Your reference: SSD 5243  
Our reference: DOC12/32439  
Contact: Stephen McClure 9995 6814

I refer to the Environmental Impact Statement (EIS) for the Stage 2A – North Penrith Mixed Use Development (SSD 5243) provided to the Office of Environment and Heritage (OEH) for review on 7 August 2012.

## **ATTACHMENT 1: EPA comments on the Stage 2A – North Penrith Mixed Use Development (SSD 5243) EIS**

Drawing Title: <b>SEDIMENT &amp; EROSION CONTROL DETAILS</b>				
Project No.: X12016	Stage: 2A	Milestone: SSD	Dwg No.: 703	Revision: 04

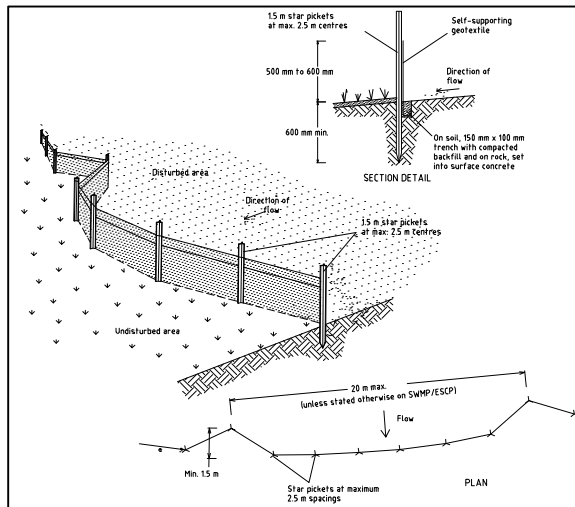
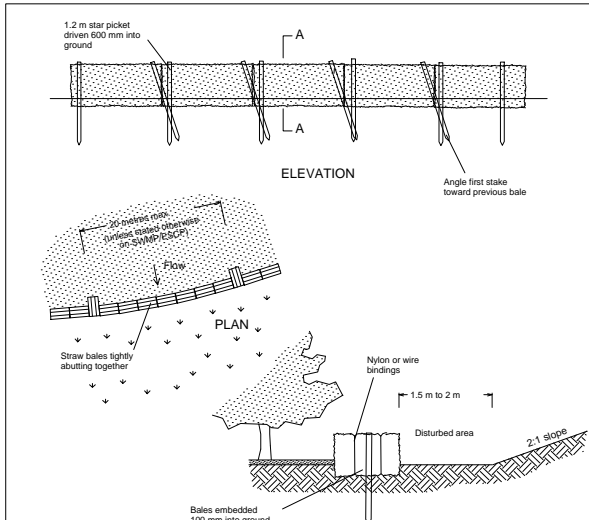
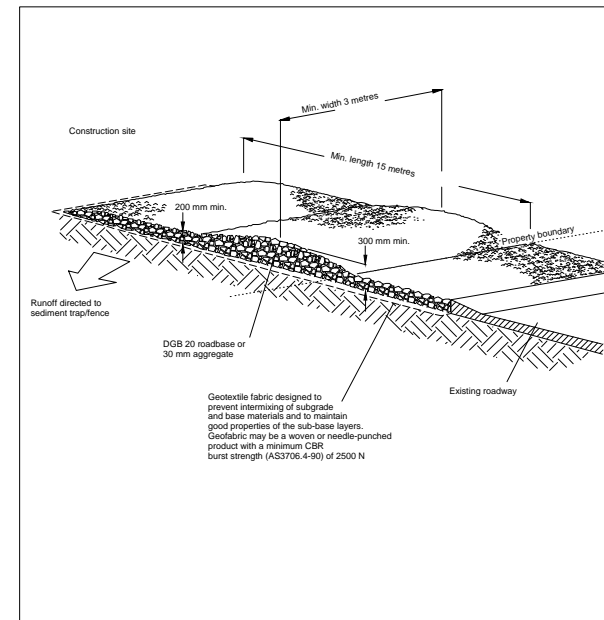
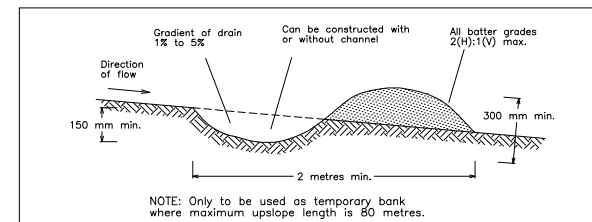
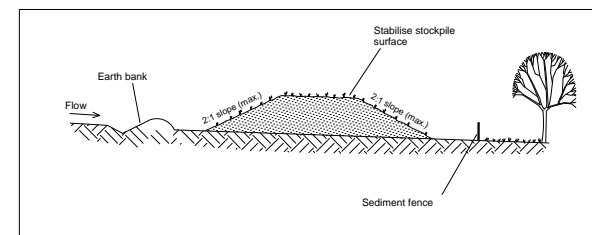
As a condition of approval the EPA recommends that the SWMP is prepared in accordance with Landcom's "*Managing Urban Stormwater-Soil and Construction*", March 2004 (the Blue Book) and in addition to the site specific erosion and sediment management measures and plans outlined in Appendix B, drawings 701, 702, and 703.
